J ROBERTS DESIGN LTD
STRUCTURAL AND CIVIL ENGINEERING CONSULTANTS

Ref – JR/4097

5 Bradleys Lane, Hoveringham, Nottingham, NG14 JG - Structural Inspection

DRAWING  
Existing Plans and Elevations

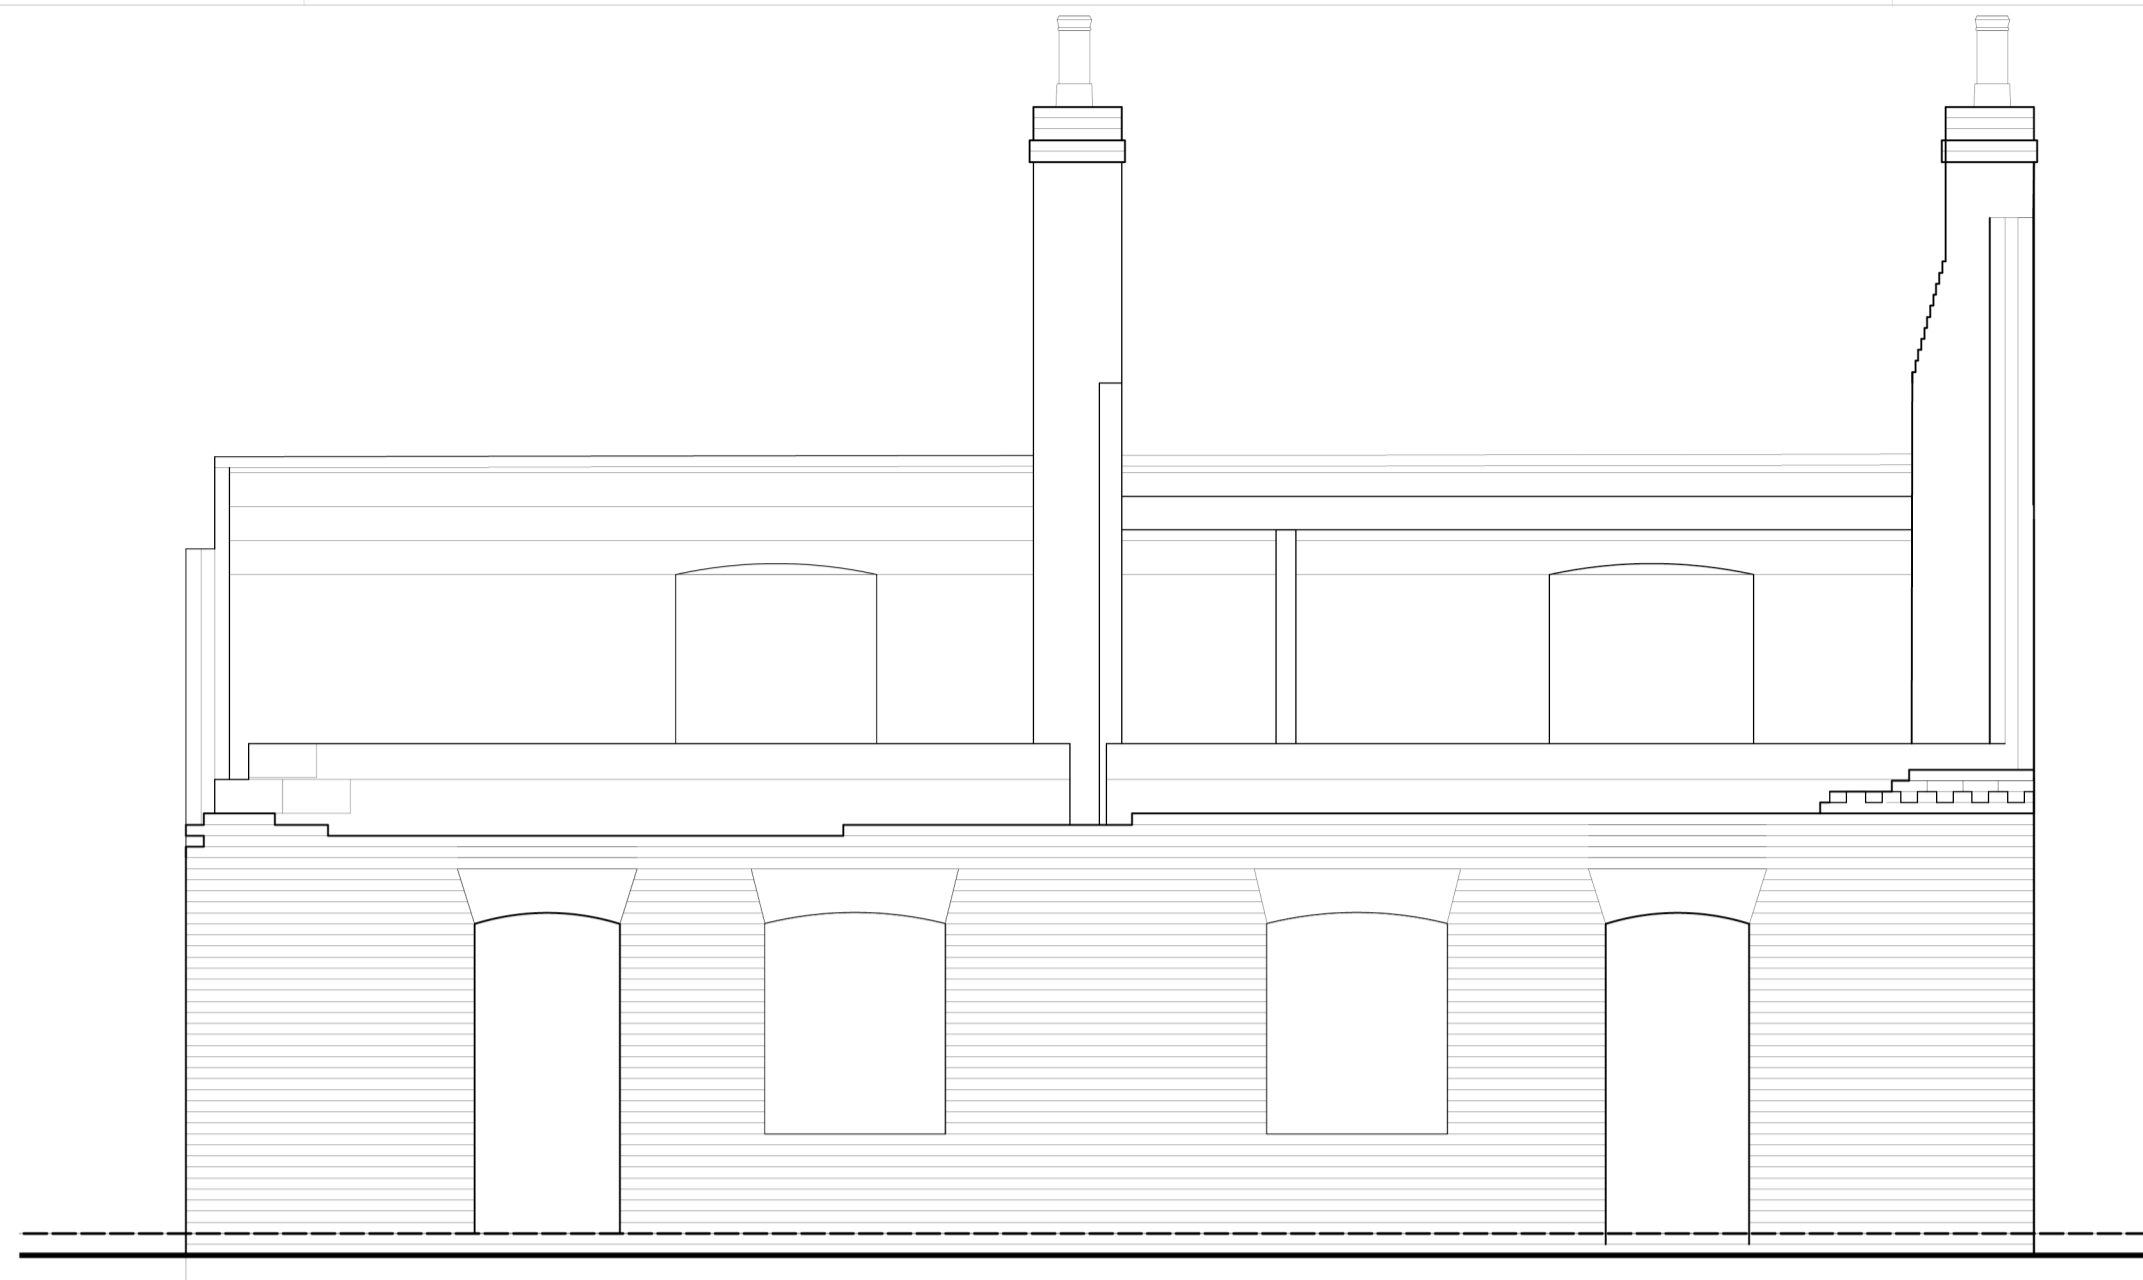
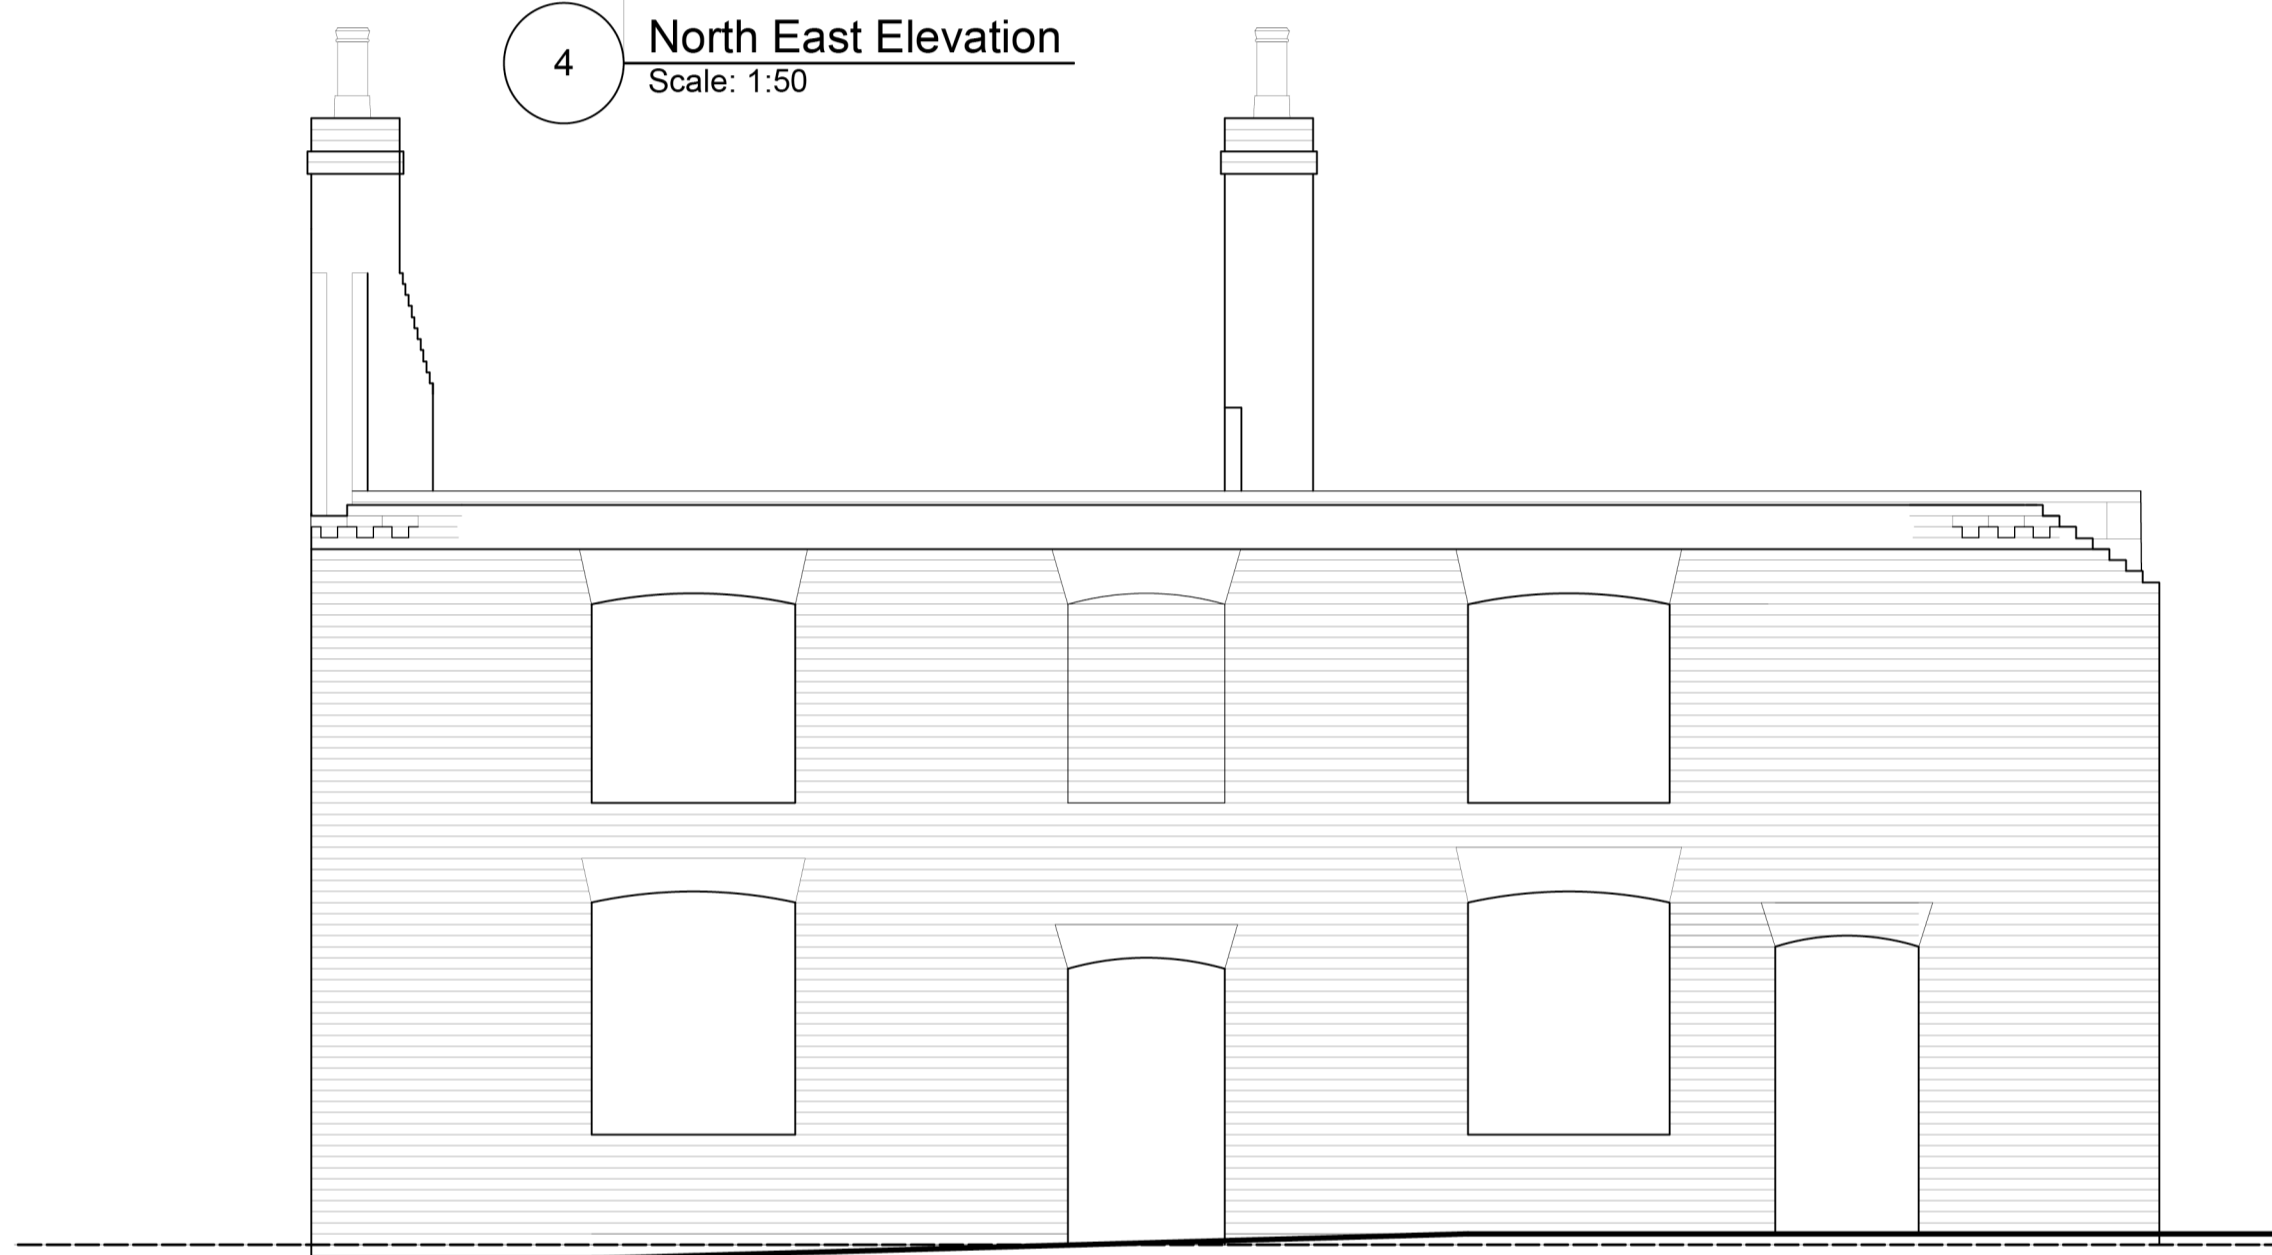
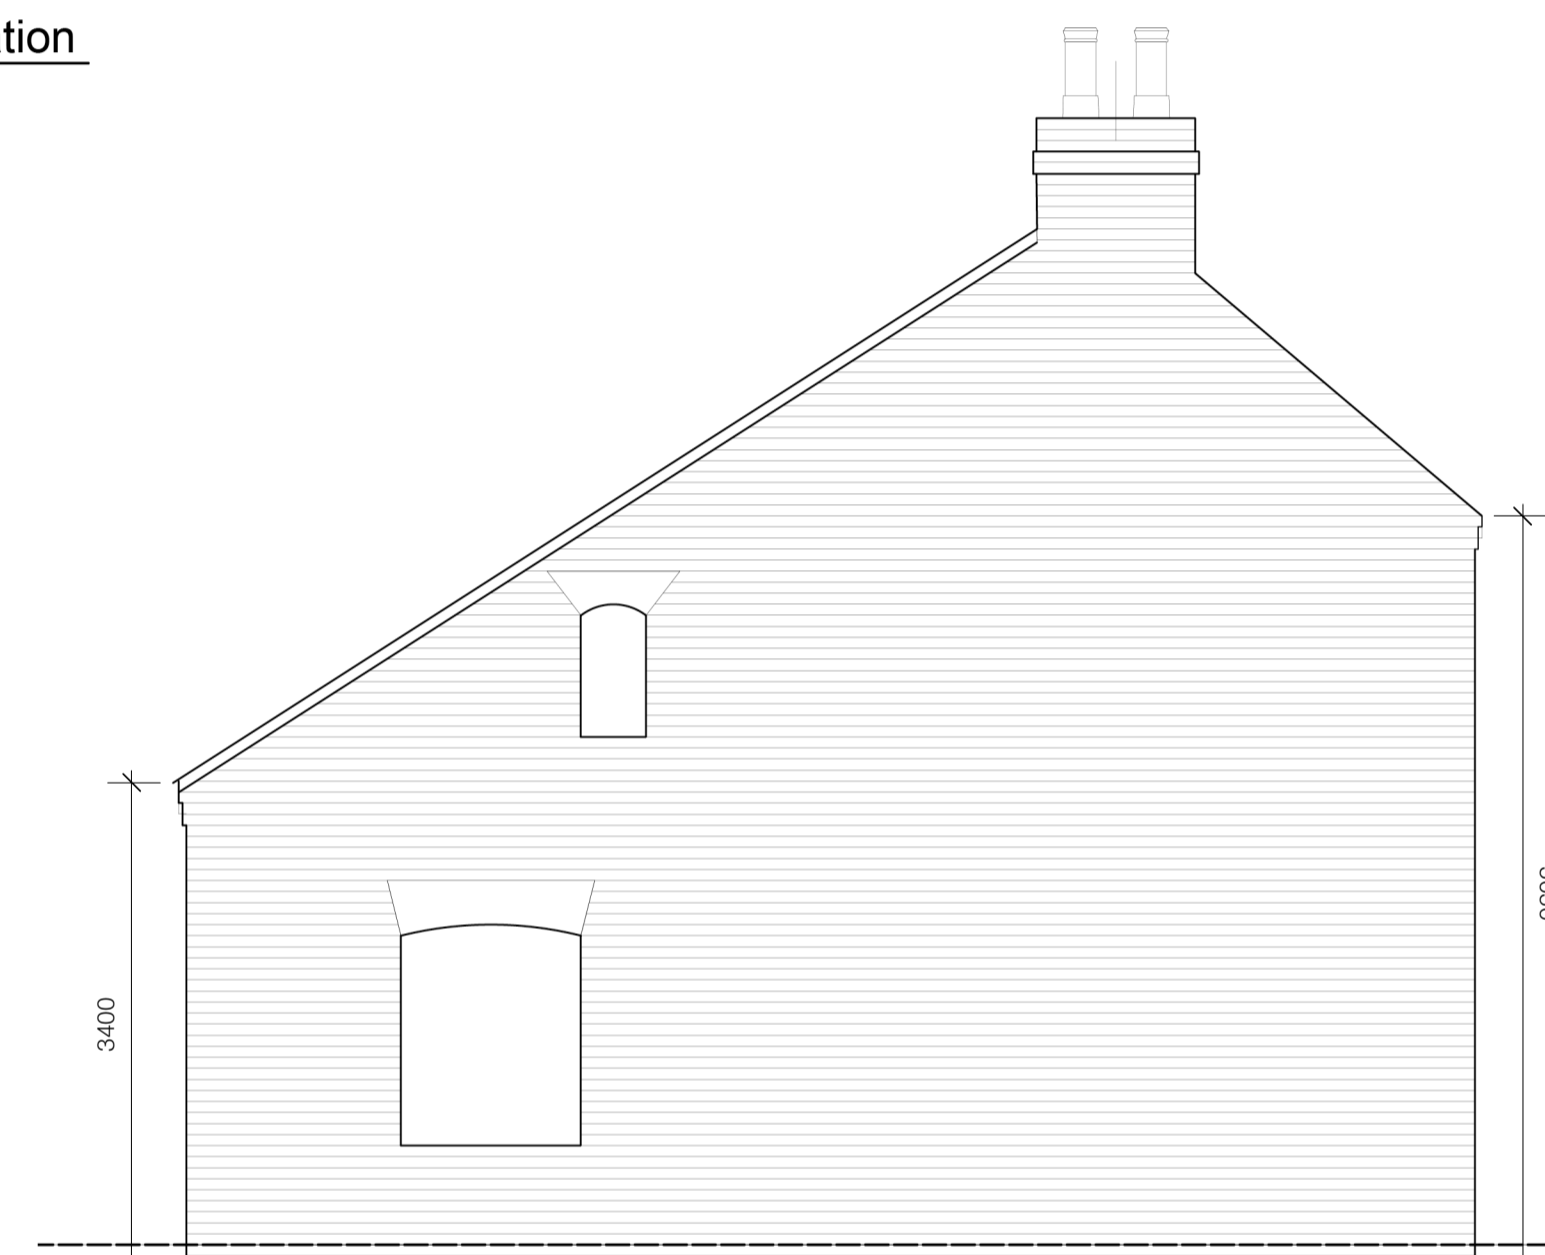
3. The plumb and level of the external and internal walls were checked at selected locations and generally no extreme dips or leans were detected.
4. Within the northern side for the property an existing internal pier appears to have settled historically by some 150mm indicated within the doorframe and wall dado rail. No vertical movement was noted on the front elevation indicating the pier is unlikely to be tied into the pier and potentially doesn't have a competent foundation.

5. On the original front elevation diagonal cracks and vertical slippage of the brick arches were observed above the ground floor window heads. The remainder of the property appears to have had new proprietary steel lintels installed as part of the extension works.

6. Continuing to the north east corner of the gable wall it appears that a section of wall had collapsed resulting in lateral movement of circa 200mm in the masonry and rotation of the masonry at the corner. Loose bricks are still present within the outerleaf of masonry. Internally cracking within the bedjoints are visible reflecting the movement observed. The corner is also noted to be an interface between the solid brick masonry and new cavity construction. The outerbrickwork has been toothed in around the corners, however the blockwork abuts the vertical face of the brickwork on the inner leaf. It is not known if masonry ties are present to the inner leaf of masonry.

The masonry fracturing and slippage of soldier coursing observed in the front wall is considered to be associated with an absence of lintel support to the outer face of brickwork, potential timber decay of the inner timber lintel and lack of a floor or roof structure providing lateral stability to the wall. We recommend the timber lintels are replaced with steel lintels, and the masonry above the window heads either repaired by crack stitching or the solid brick masonry is rebuilt locally.

The defects to the north gable will require the partial demolition of the defective areas of masonry and effective re-building of the corner up to the proposed gable wall level. The inner leaf of blockwork will need to be effectively tied into the solid brickwork at the corner with remedial ties where new or crack stitching around the internal corner of the wall where the blockwork is to remain in place.

The internal pier that has apparently dropped is proposed to be removed as part of the new dwelling configuration, hence no further remedial works for the pier are required.
